From: [Kerren Ven](#)
To: shaun.williams@planning.nsw.gov.au
Subject: RE: Horsley Park Brickworks Plant 2 Mod 1(SSD-9601-Mod-1)- Reminder of Due Date for Response to Planner
Date: Monday, 2 May 2022 9:39:49 AM
Attachments: [image007.png](#)
[image010.png](#)
[image011.png](#)
[image012.png](#)
[image013.png](#)
[image014.jpg](#)
[image015.jpg](#)
[image016.jpg](#)
[image017.png](#)

Council officers have reviewed the applicant's Response to Submission Report and supporting information and note the remaining matters relate to traffic matters for consideration. The following information is requested for further consideration on the proposed modification.

B-Double (26.0m)  
Overall Length 26.000m  
Overall Width 2.500m  
Overall Body Height 4.300m  
Min Body Ground Clearance 0.540m  
Track Width 2.500m  
Lock-to-lock time 6.00s  
Curb to Curb Turning Radius 15.000m  
Design Speed 10km/hr

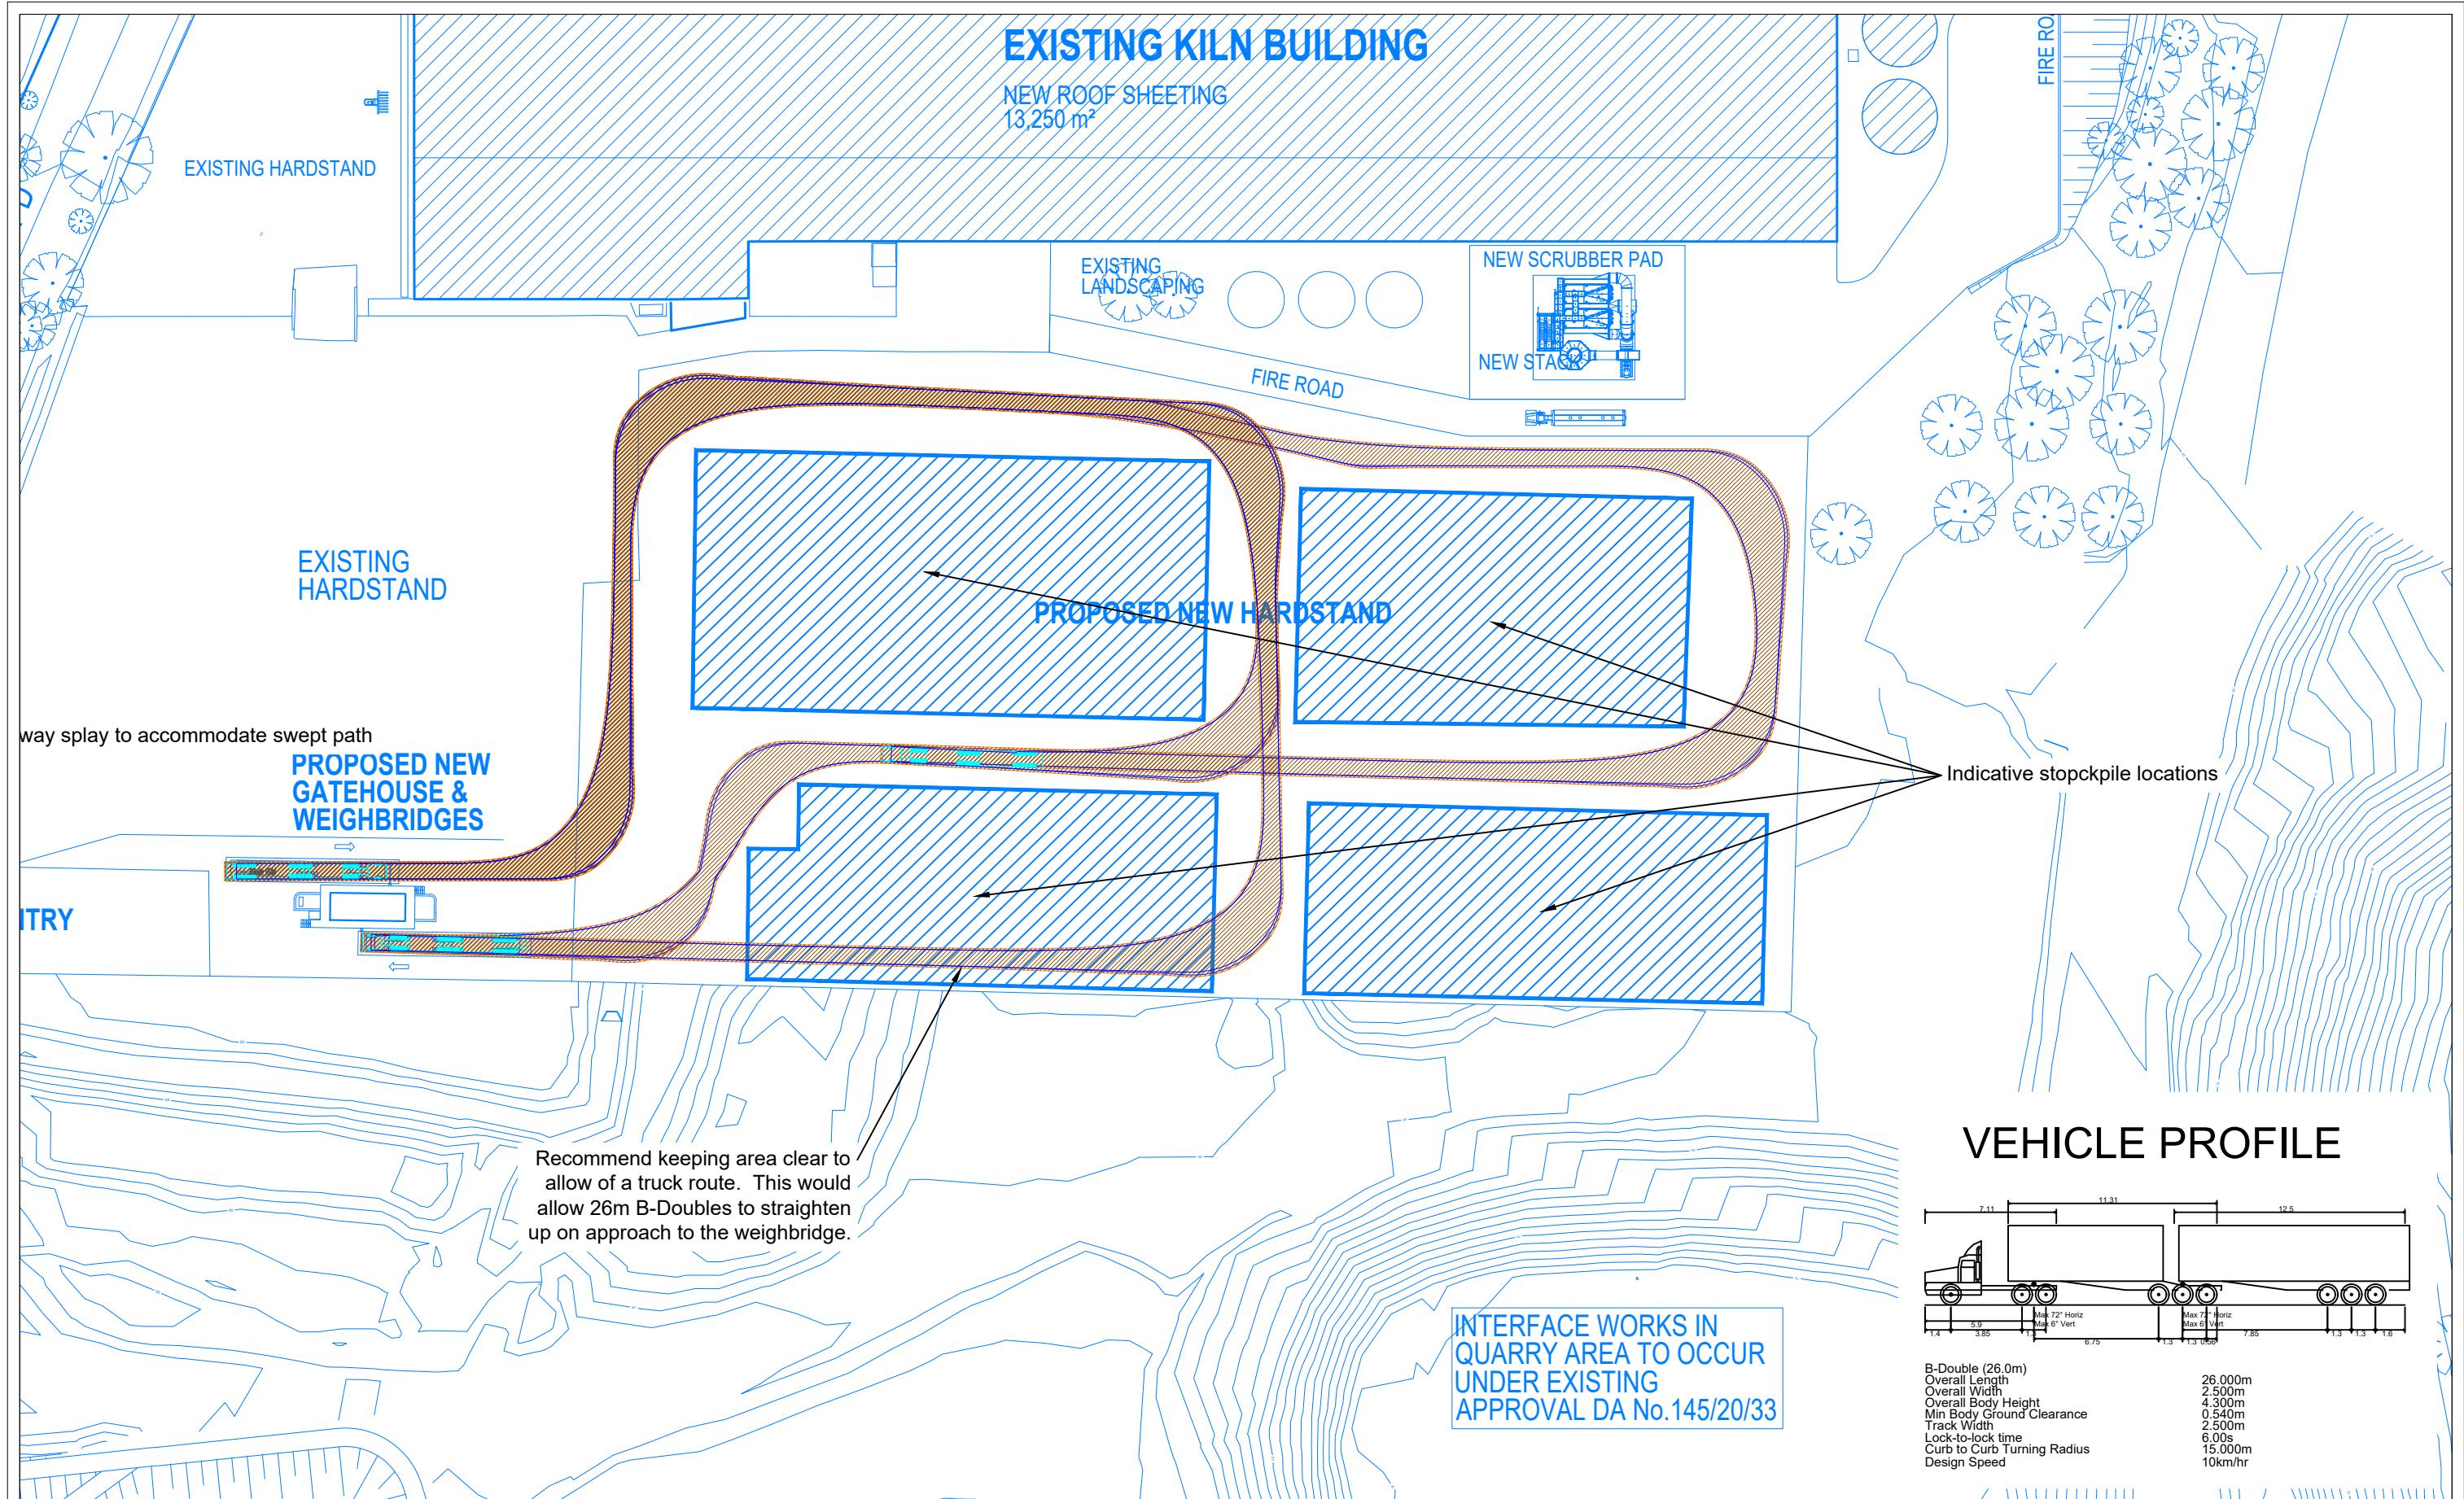
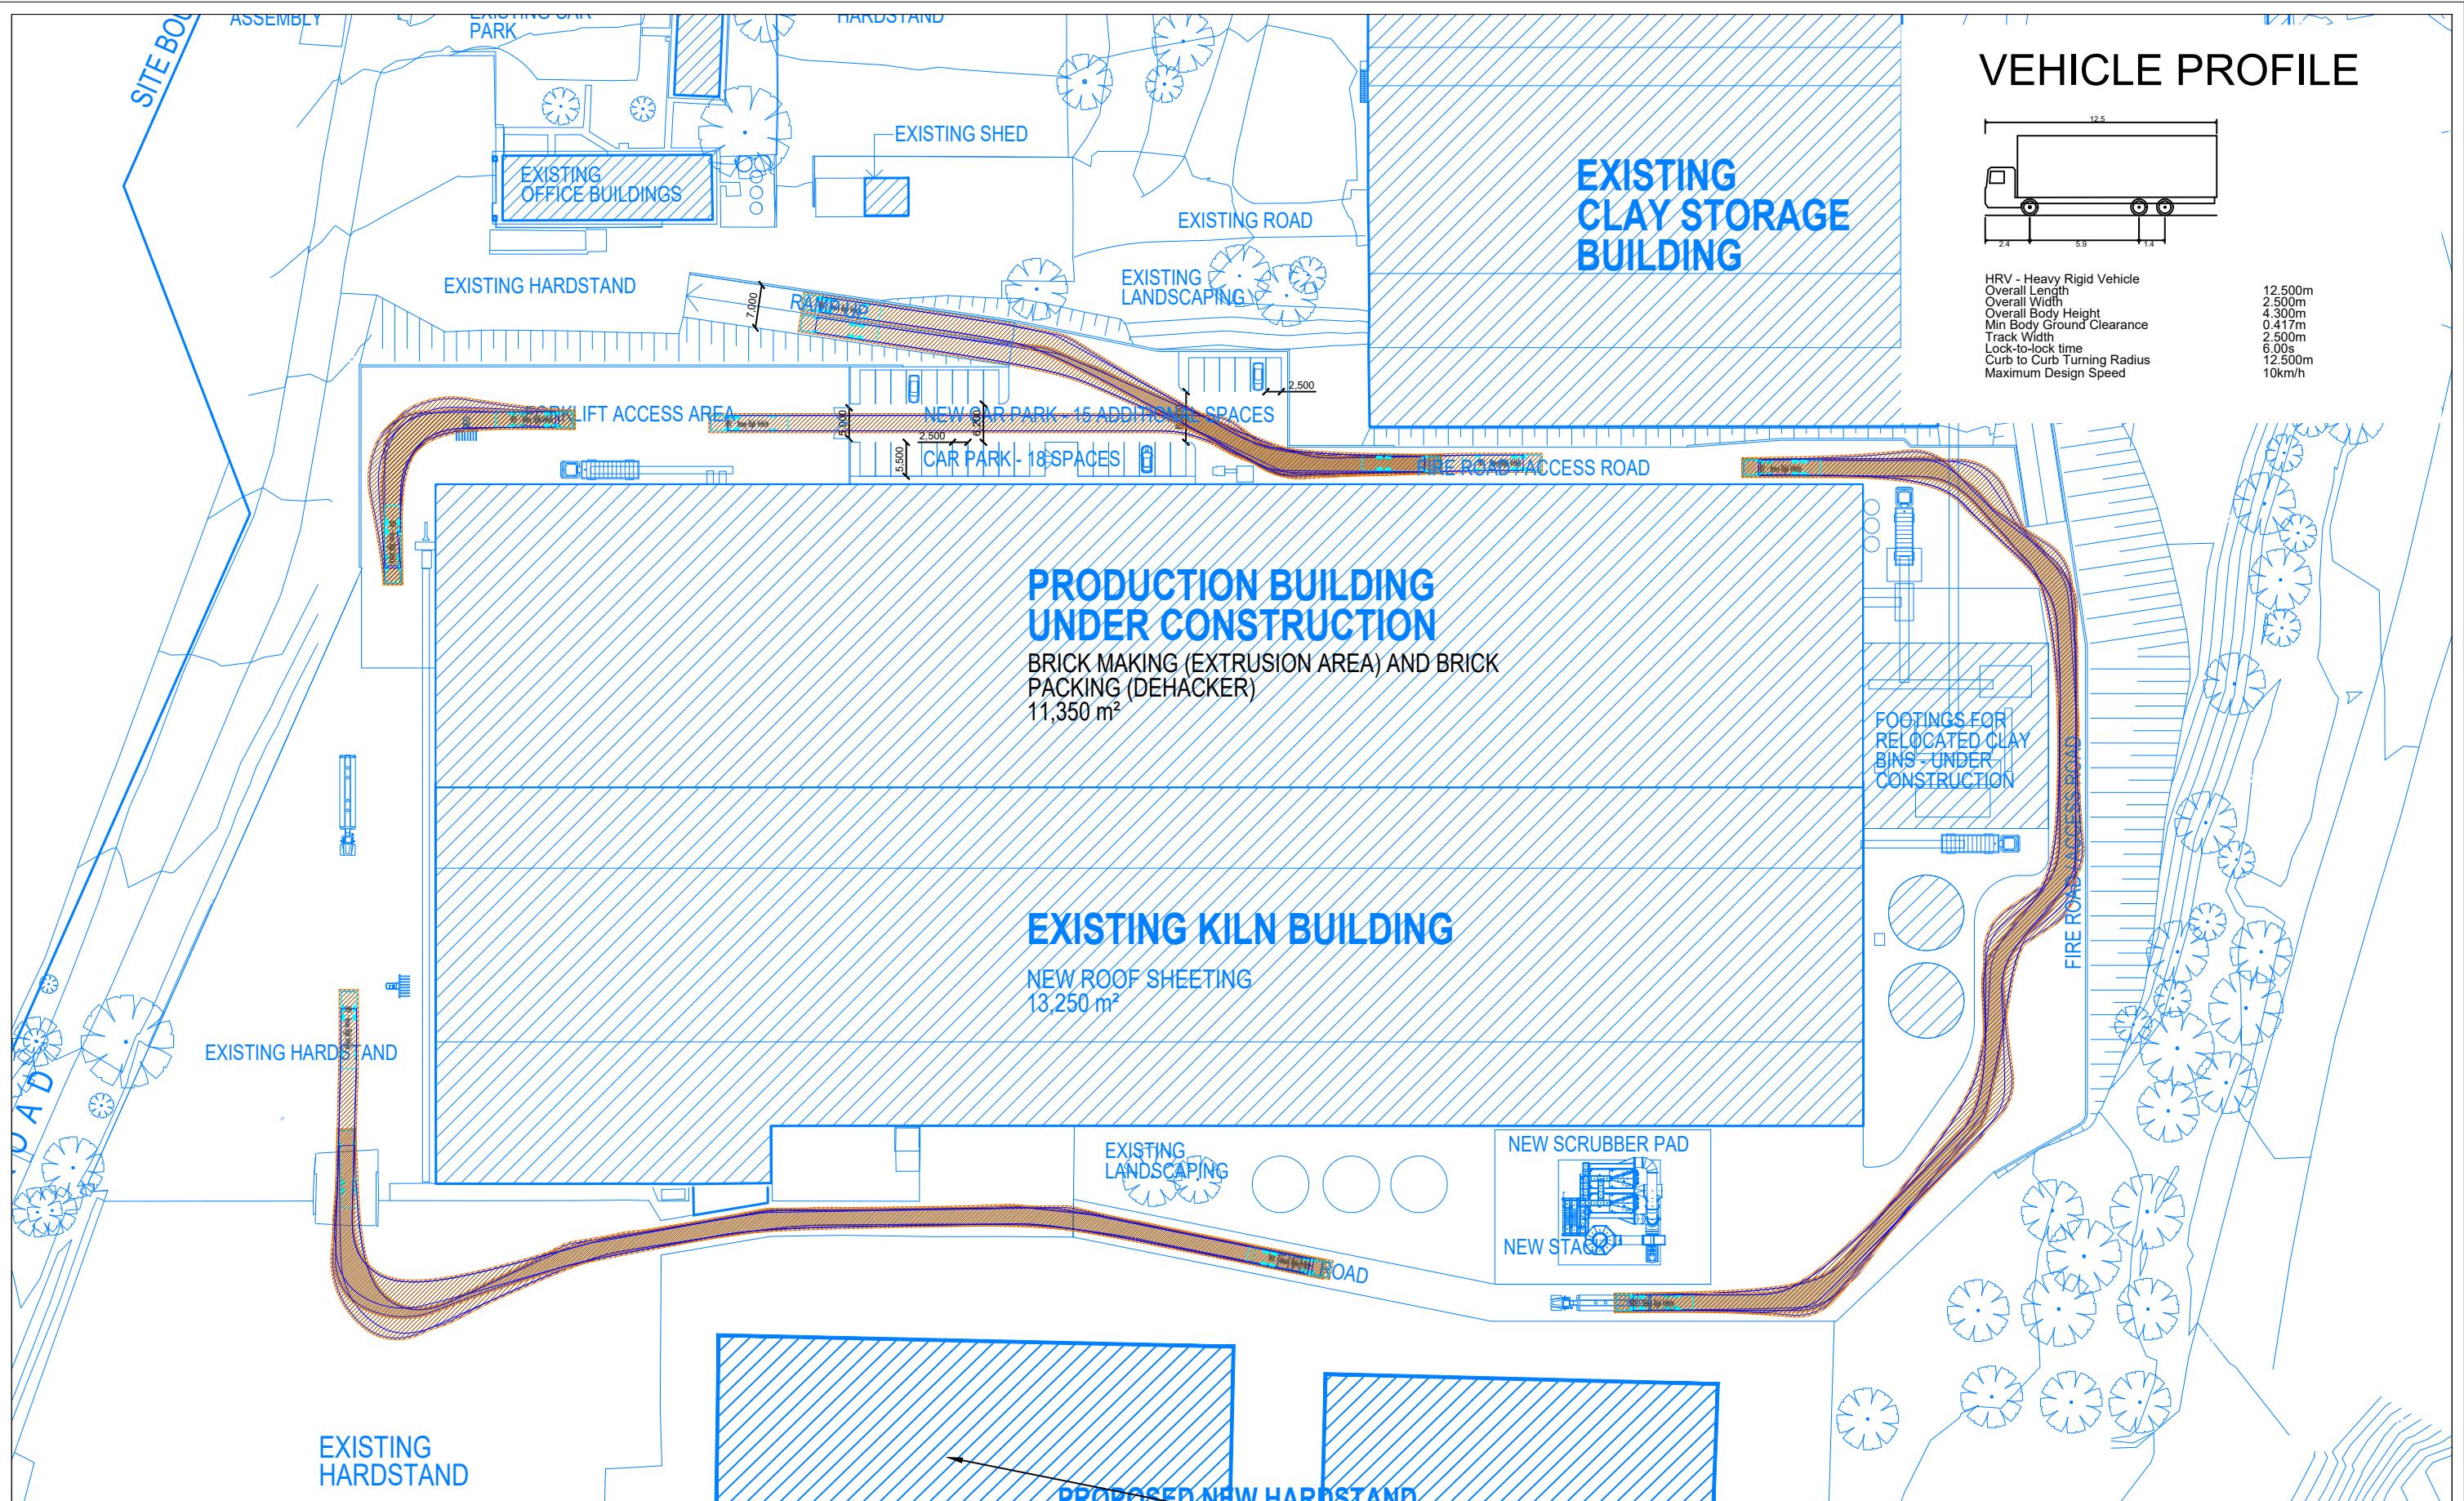
3. Australian Standards (AS 2890.2:2018) does not specify a requirement for the maximum permissible allowable ramp grade for 26m B-Double vehicle. The applicant shall carry out investigation and submit additional information to Council for assessment regarding this matter;

4. The applicant shall provide swept path diagram(s) to demonstrate the intersection areas within the site have sufficient capacity to cater for two-way traffic movements;

5. With regard to heavy vehicles manoeuvring within the site, the applicant's swept path diagrams shall demonstrate how heavy vehicles can satisfactorily manoeuvre into and out of the proposed new hardstand areas. This is to ensure that the design of the hardstand areas will be sufficient to accommodate the intended design vehicles. The plan shall be updated to show where one-way traffic flow is proposed within the site. Where two-way movements are permitted at the intersection areas, swept path analysis demonstrating that two-way simultaneous movements for the possible scenarios shall be shown; and
